Application for a non-material amendment following a grant of planning permission.
Town and Country Planning Act 1990

Conversion of the existing garage into a habitable room, single storey extension to the rear and new flat and pitched roof that will replace the existing flat roofs

23/04149/FUL

PROPOSED FRONT ELEVATION

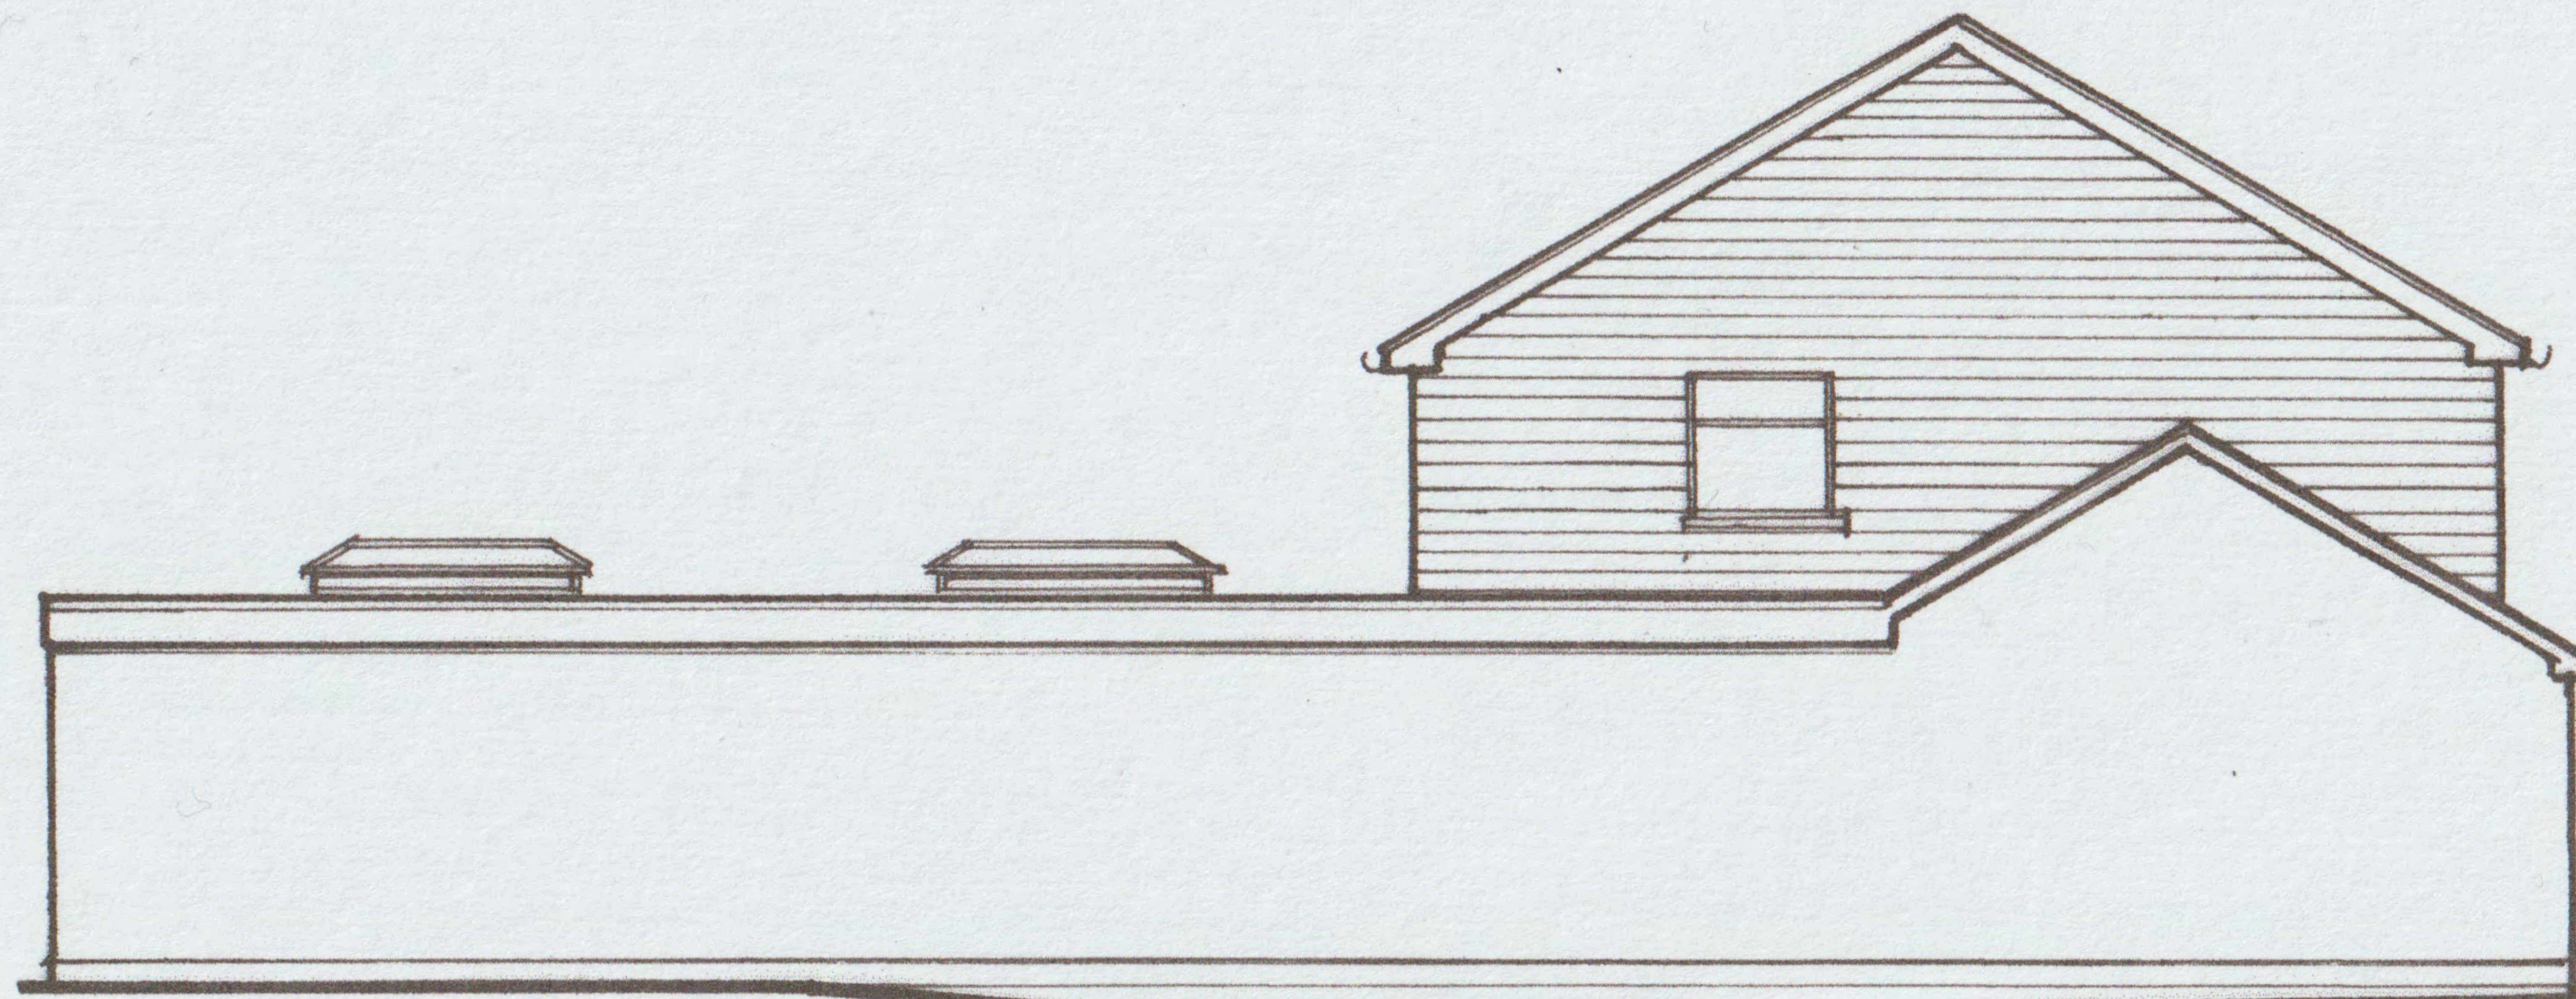
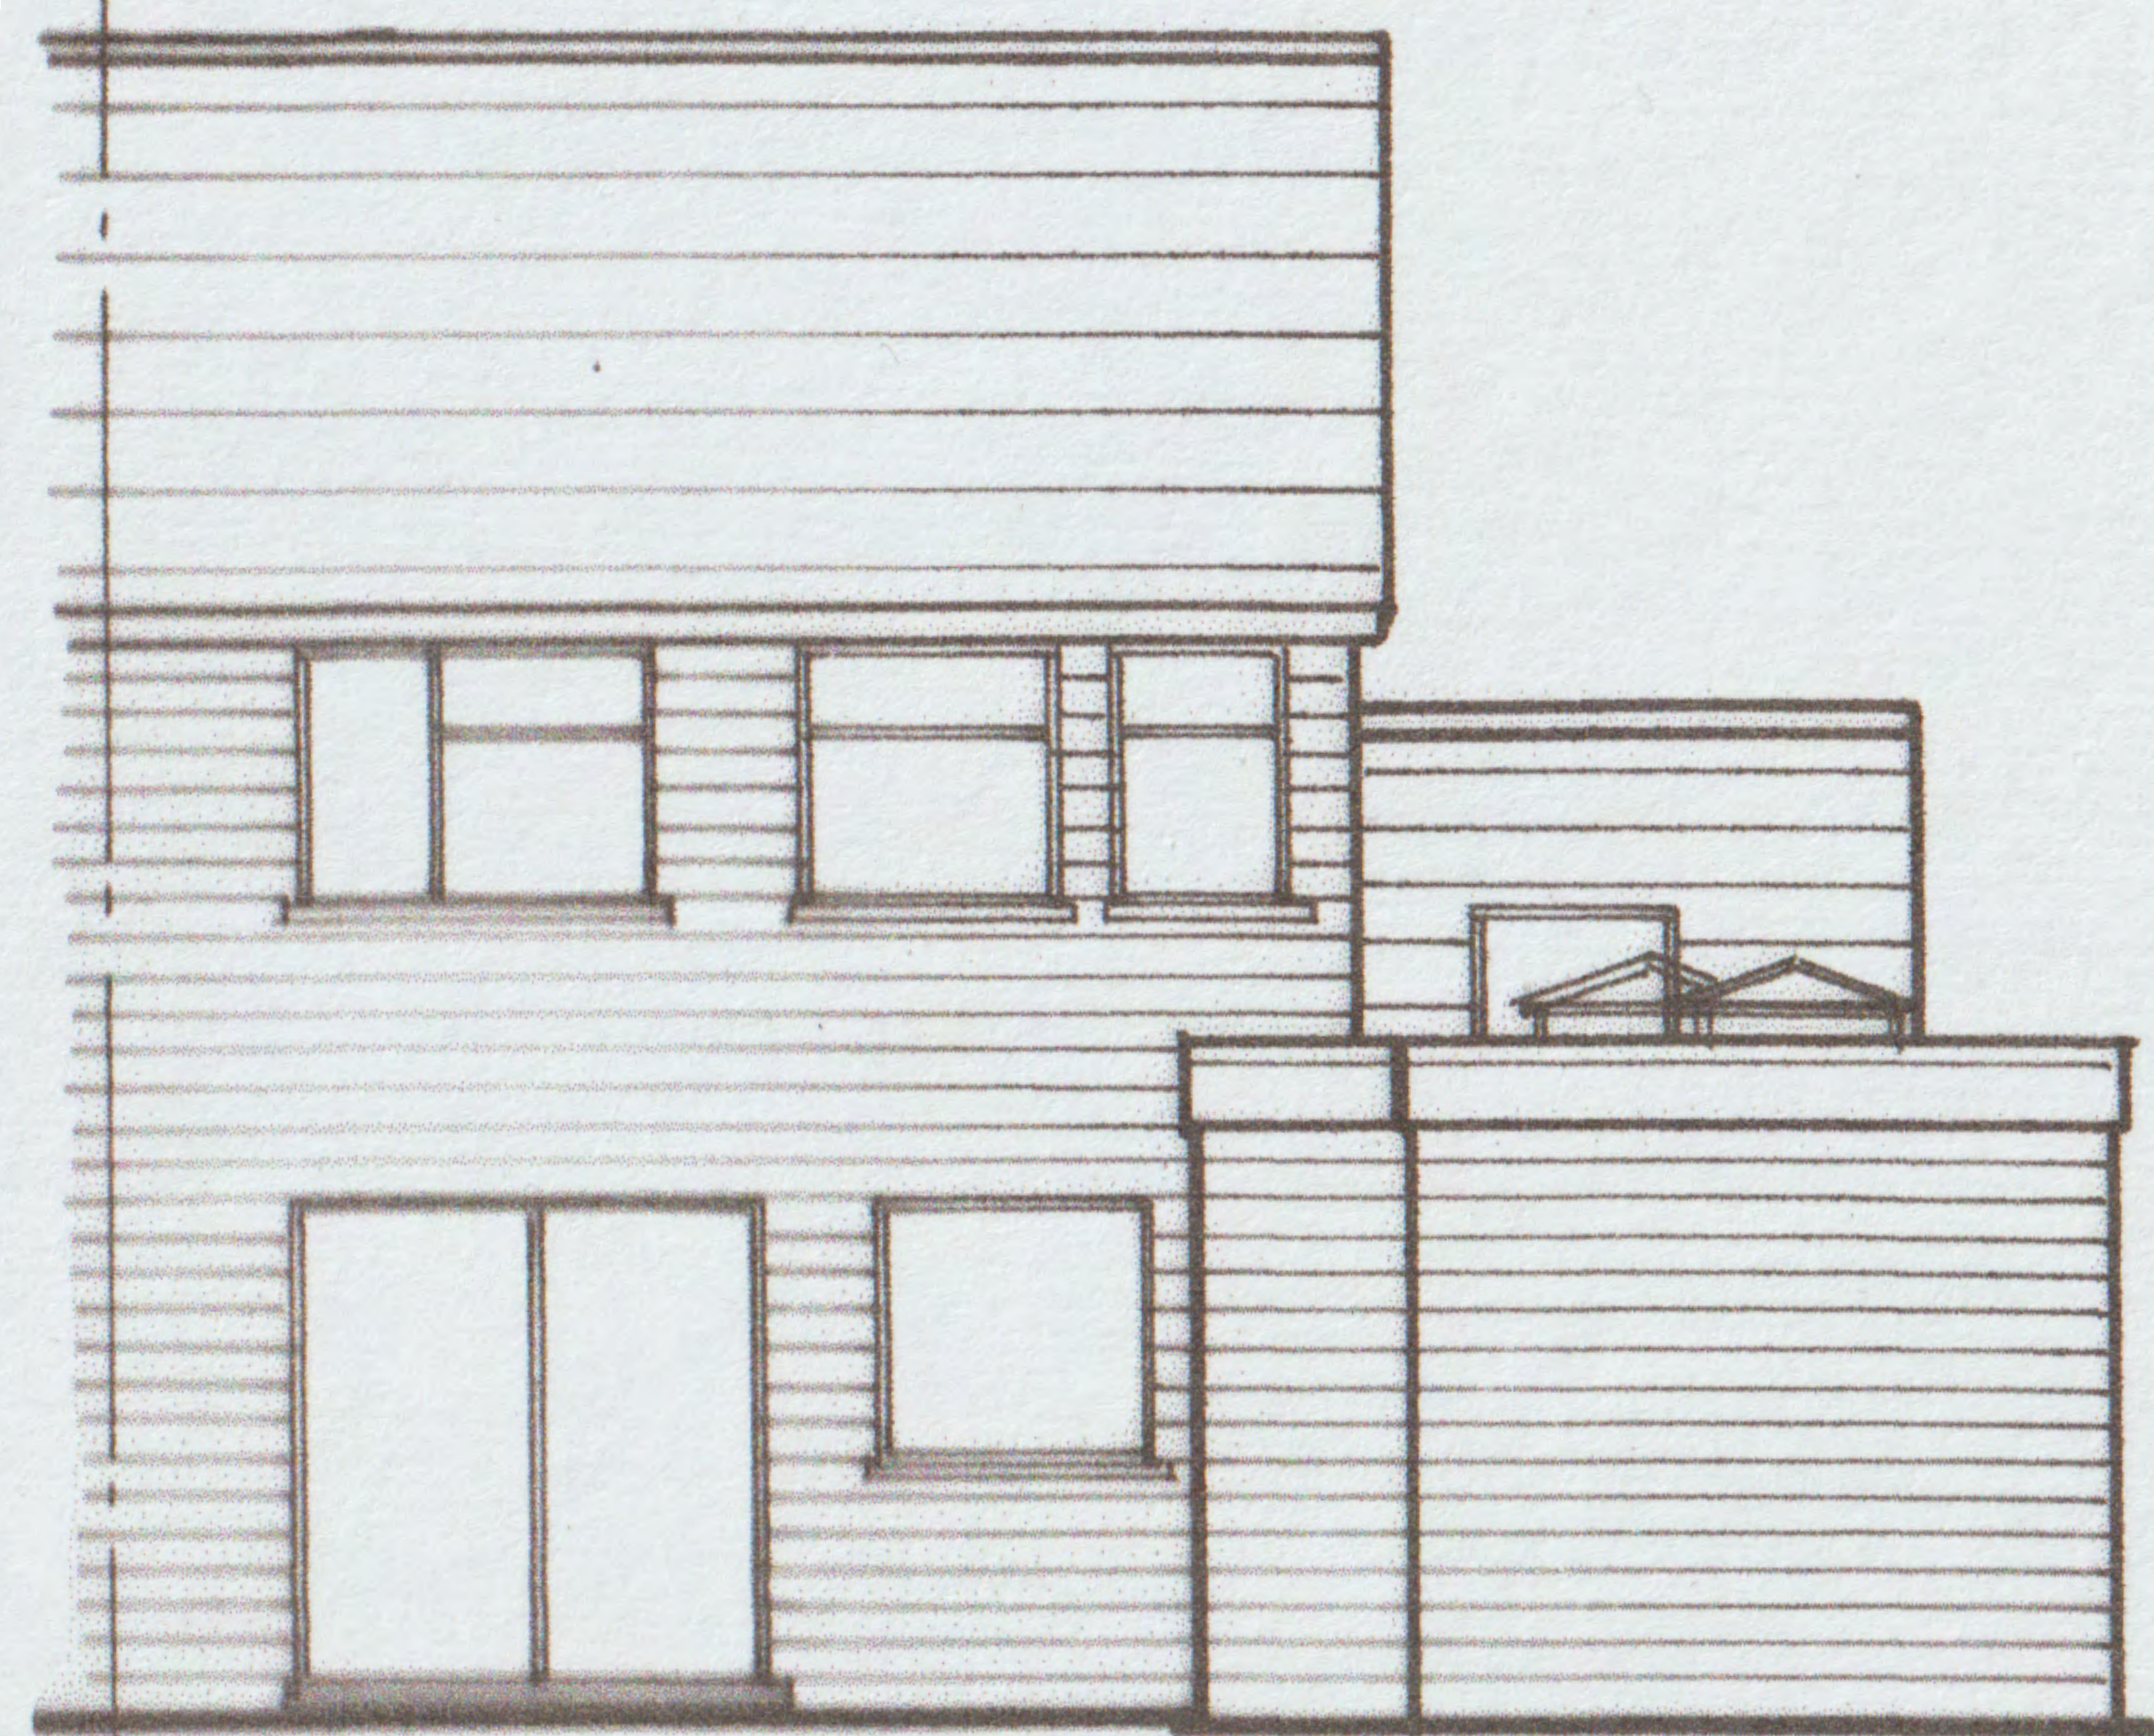
The style, texture and colour of the original brickwork can't be matched as the brick is now not manufactured so a good match is not possible, so it is intended to render the extension

As explained the brick will not match
